Attachment A – Response to Agency Submissions (SSD 7275) 80-88 Regent St, Redfern

The following table includes a response to the full text of submissions provided by or on behalf of State and local government agencies. For completeness, the full text of each submission is provided in the left-hand column, accompanied by the proponent's corresponding response in the right-hand column. The proponent's responses have been informed by input by the expert consultant team and should be read in conjunction with the publicly exhibited Environmental Impact Statement and accompanying technical reports, as well as the Response to Submissions Cover Letter to which this document is appended.

Roof Terrace level

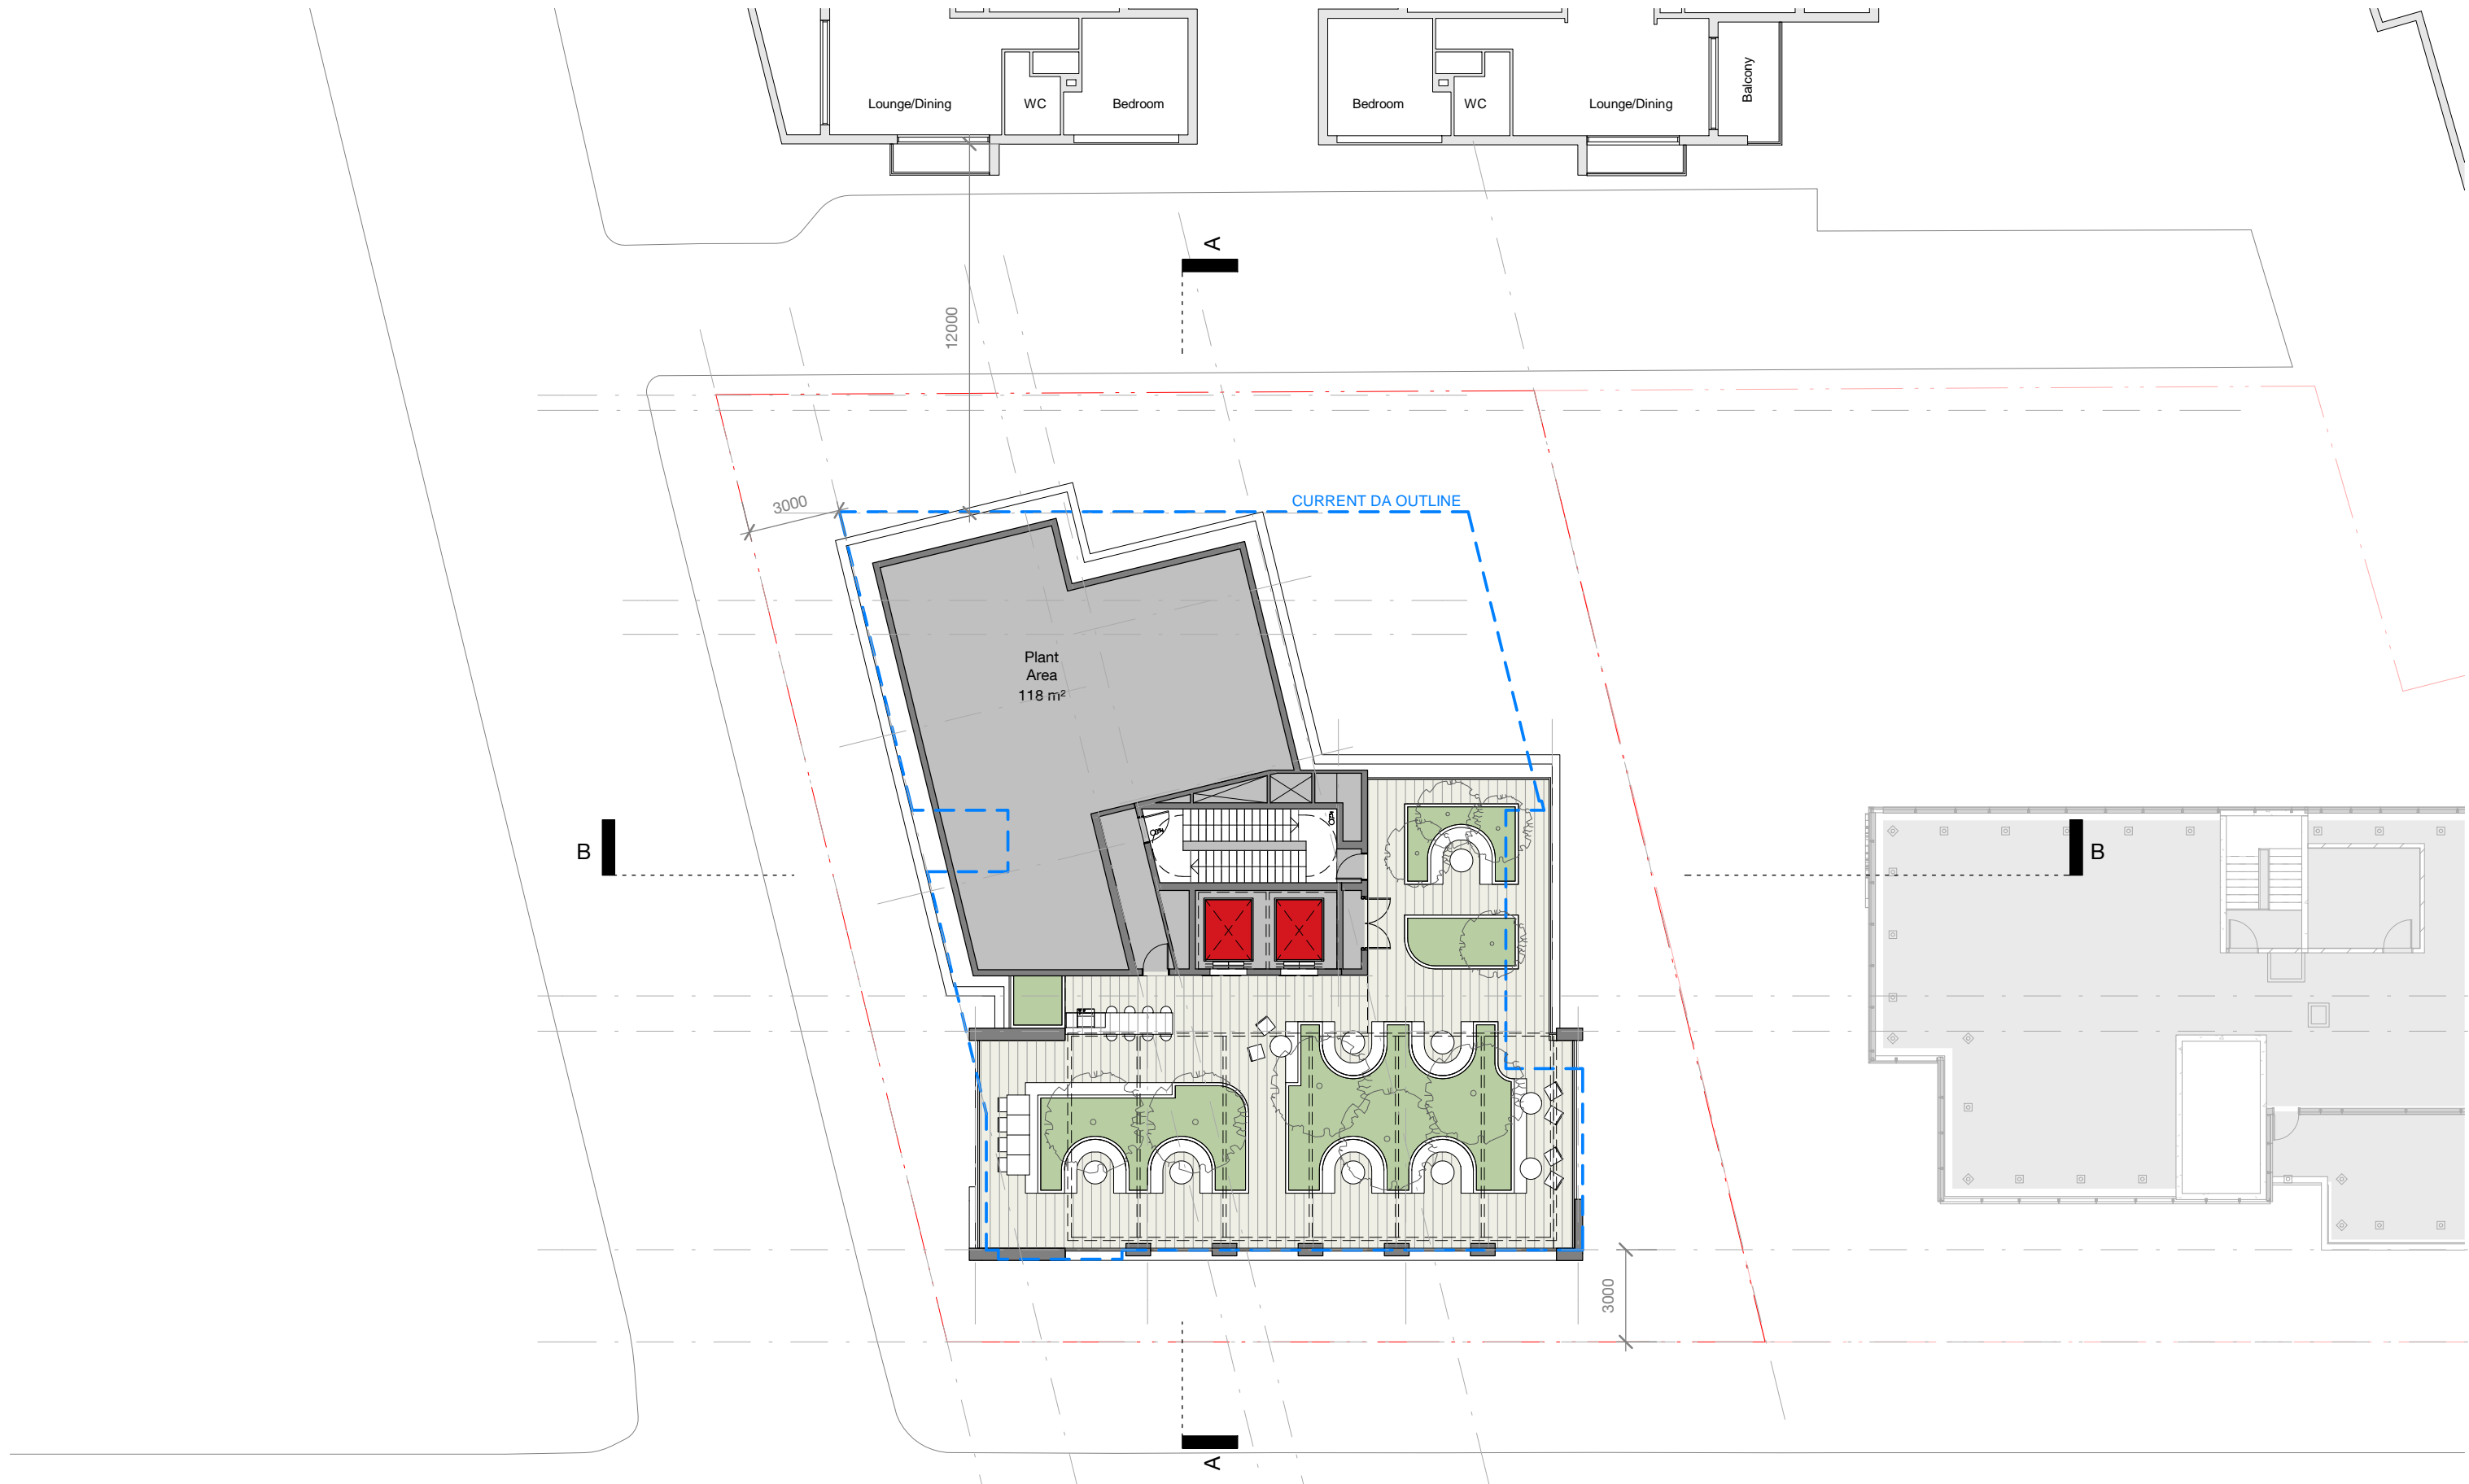
CoS 14c	While the quantity of common open space complies with the DCP, a review of the provision highlights that the majority of space is timber decking on slab with no porous surfaces and the amount of planters is minimal at 23%. The DCP requires that unpaved soft or porous areas must comprise a minimum of 50% of the total area of common open space	The provisions of a DCP do not apply to State Significant Development in accordance with Clause 11 of <i>State Environmental Planning Policy (State and Regional Development) 2011</i> . Notwithstanding this, the proposed development contains an additional 292m ² of outdoor communal open space which is significantly in excess of the Sydney DCP requirement for 20m ² .
CoS 14d	<u>Level 17 rooftop terrace</u>	360 has reviewed Council's landscape comments and provide the following responses.

Item Raised	Proponent's Response
<p>Confirmation of the tree locations, soil volume and justification of why the planters cannot be increased in height to provide the minimum soil depths is required.</p>	<p>There is a total of 9 Trees located within planters on the Level 17 Roof Terrace, (7 x Cupaniopsis anacardioides and 3 x Citrus sp.). The finished level of the planters are 800mm above the finished deck level, with an internal depth of 900mm. The heights of these planters are appropriate to creating a space which is both functional for providing seating pockets, maintaining views and providing appropriate soil volumes while managing dead load capacity on the structural slab. An increase in planter height is not only functionally inappropriate, as they would then impeded views and diminish the value of the roofs amenity, it would also substantially increase the loading required on the structure which cannot be accommodated. The planters have extensive lateral volume with an overall area of 47m² and allow sufficient soil for healthy tree growth and development.</p>

Elevation West

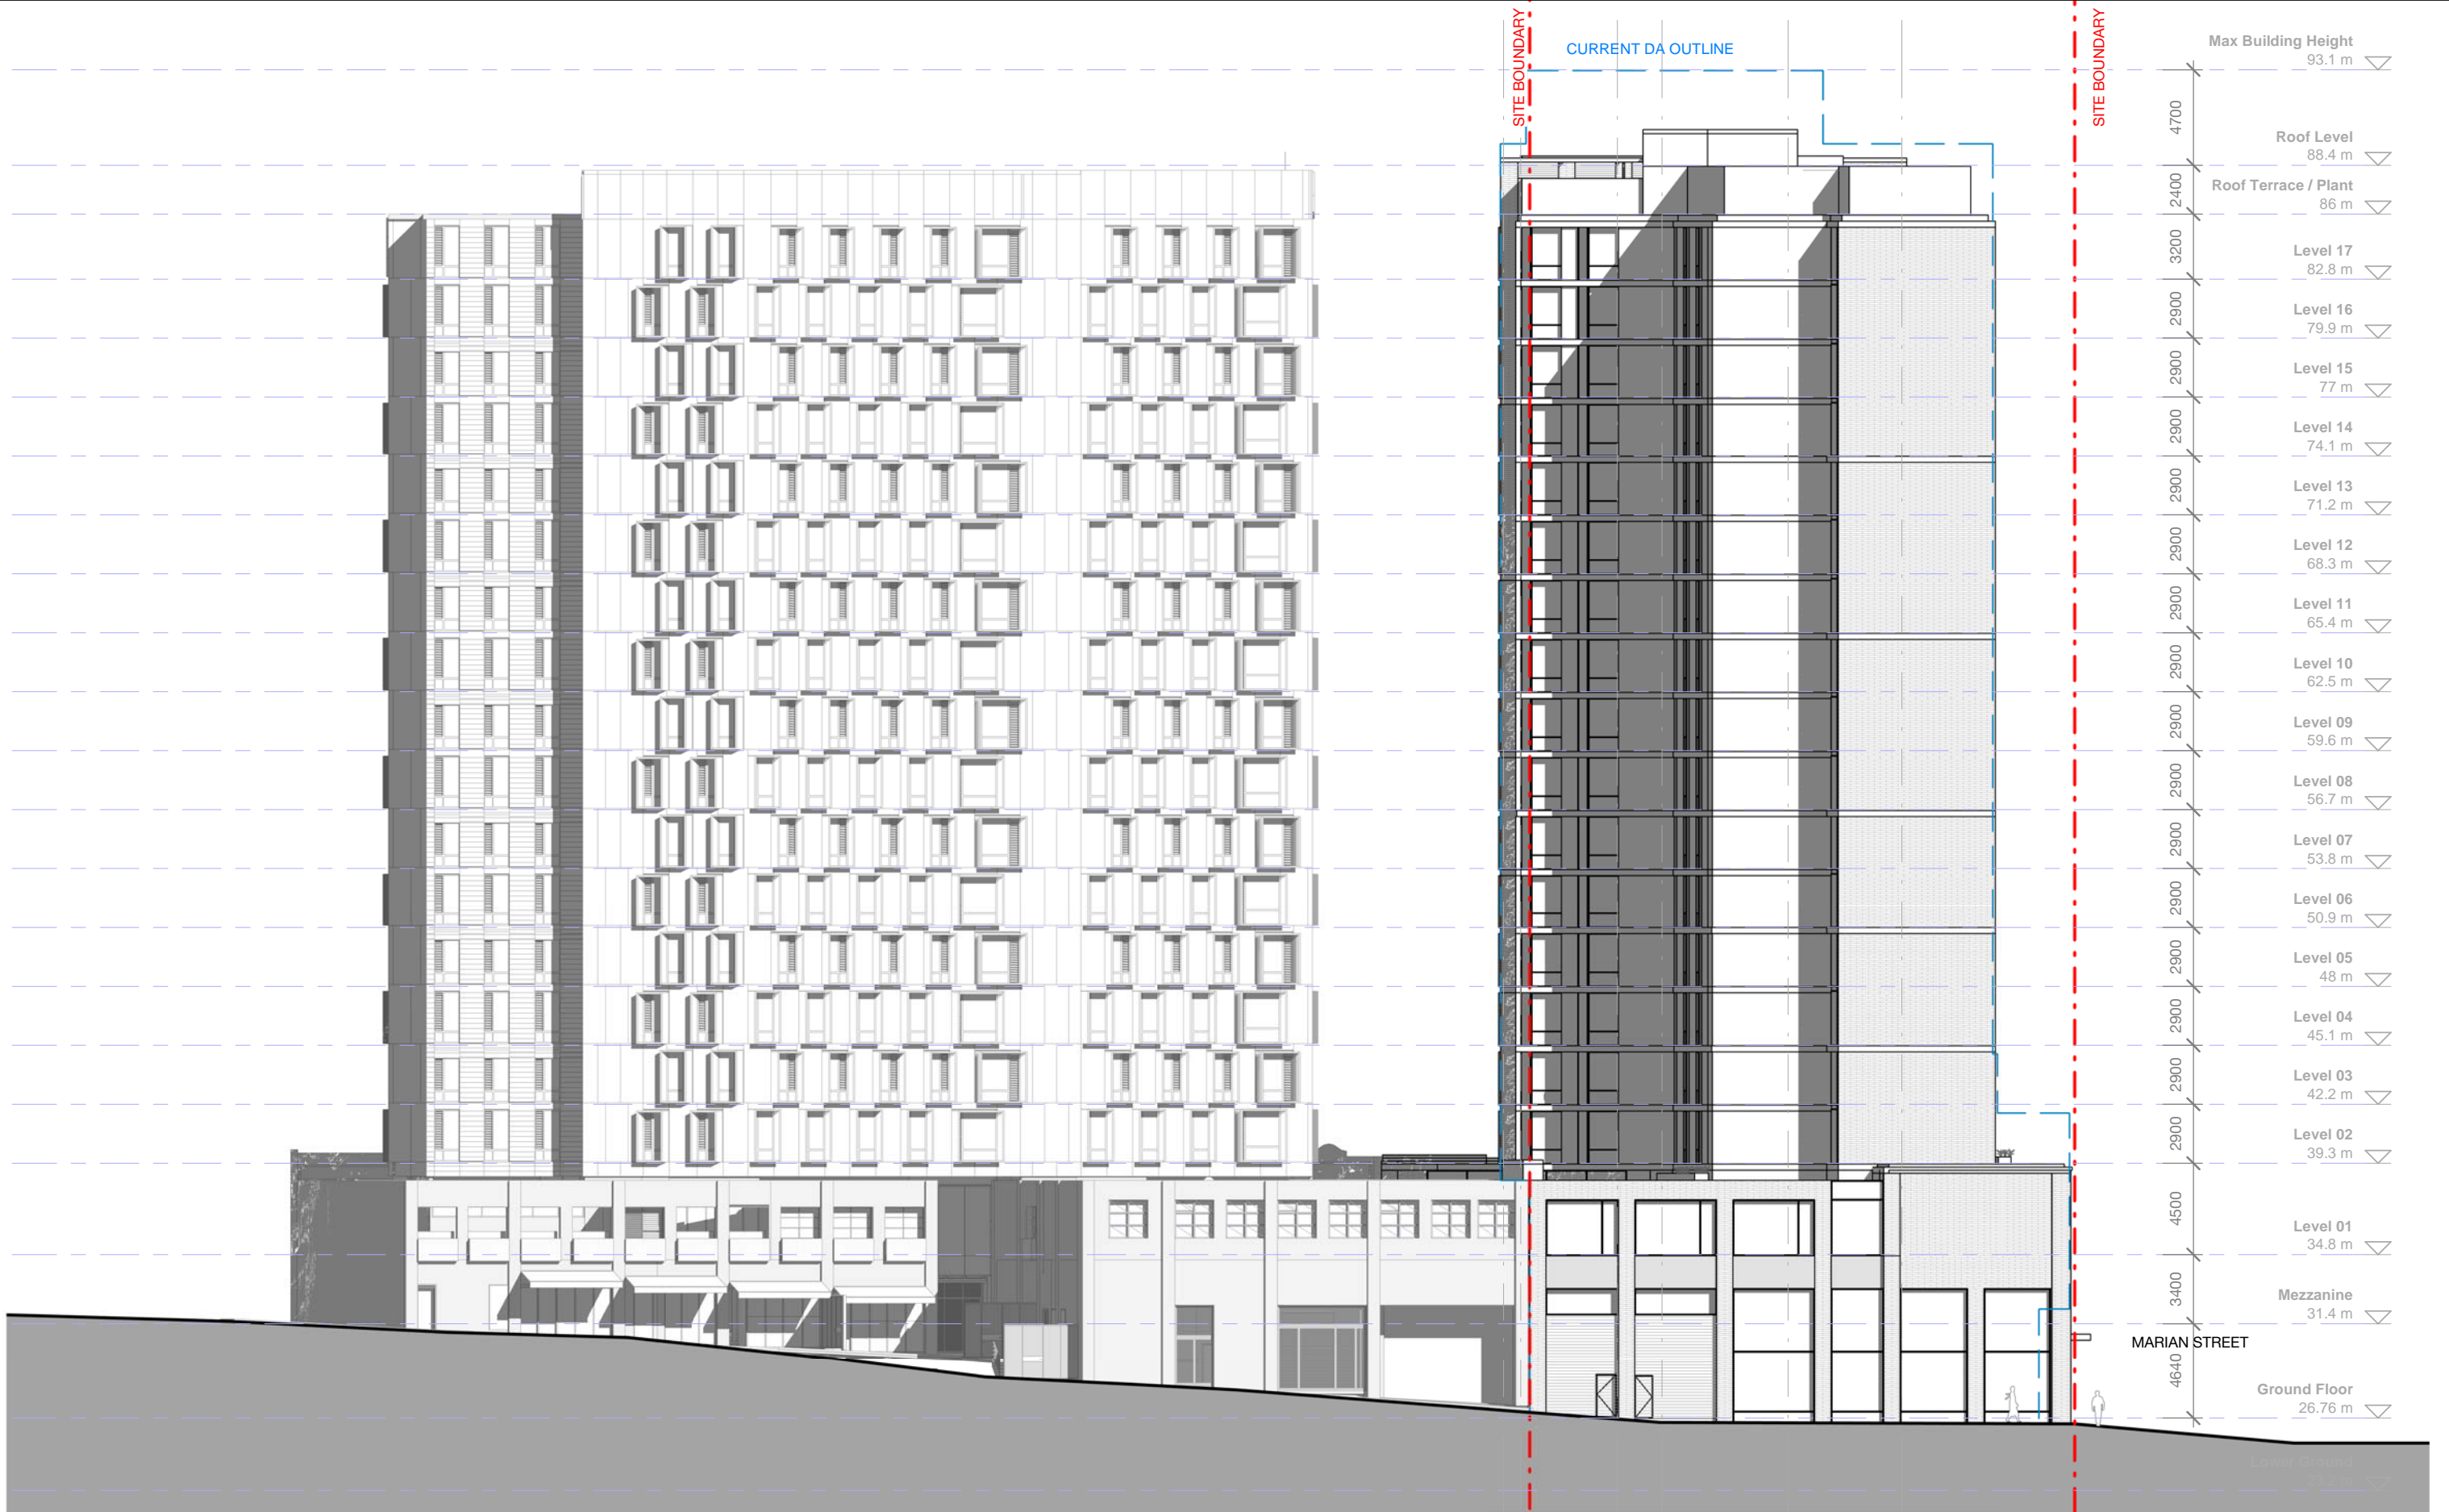
Item Raised		Proponent's Response
	The design of the podium fenestration requires further consideration / justification. The large blank section of brickwork at Level 1 to Marian Street is uncharacteristic in the local context where the upper level presents an opening to the street, particularly at corners. The plan indicates seating immediately behind the blank wall – there is no reason why this cannot also be glazed.	The proposed development includes new brick and concrete facades to the podium to draw on the character of the existing brick terraces fronting Regent Street. The Marian Street podium façade includes a mix of brickwork and glazing creating a balanced design that achieves high amenity to the Level 1 space whilst promoting passive surveillance.
CoS 13a	Land Contamination As recommended in the applicant's Preliminary Site Assessment report, a Detailed Environmental Site Investigation (DESI) is to be carried out by a suitably qualified and competent environmental consultant in accordance with the Office of Environment and Heritage, Guidelines for Consultants Reporting on Contaminated Sites, Contaminated land Management Act 1997 and SEPP 55 confirming that the site is suitable (or will be suitable, after remediation) for the proposed use.	The site has been subject to previous site investigations including the preparation of a Detailed Site Investigation (DSI) for the previous application under SSD 7080. Accordingly, the existing DSI prepared by EA Australia is provided at Attachment M and the cover letter at Attachment L confirms that the site is suitable for the proposed development.
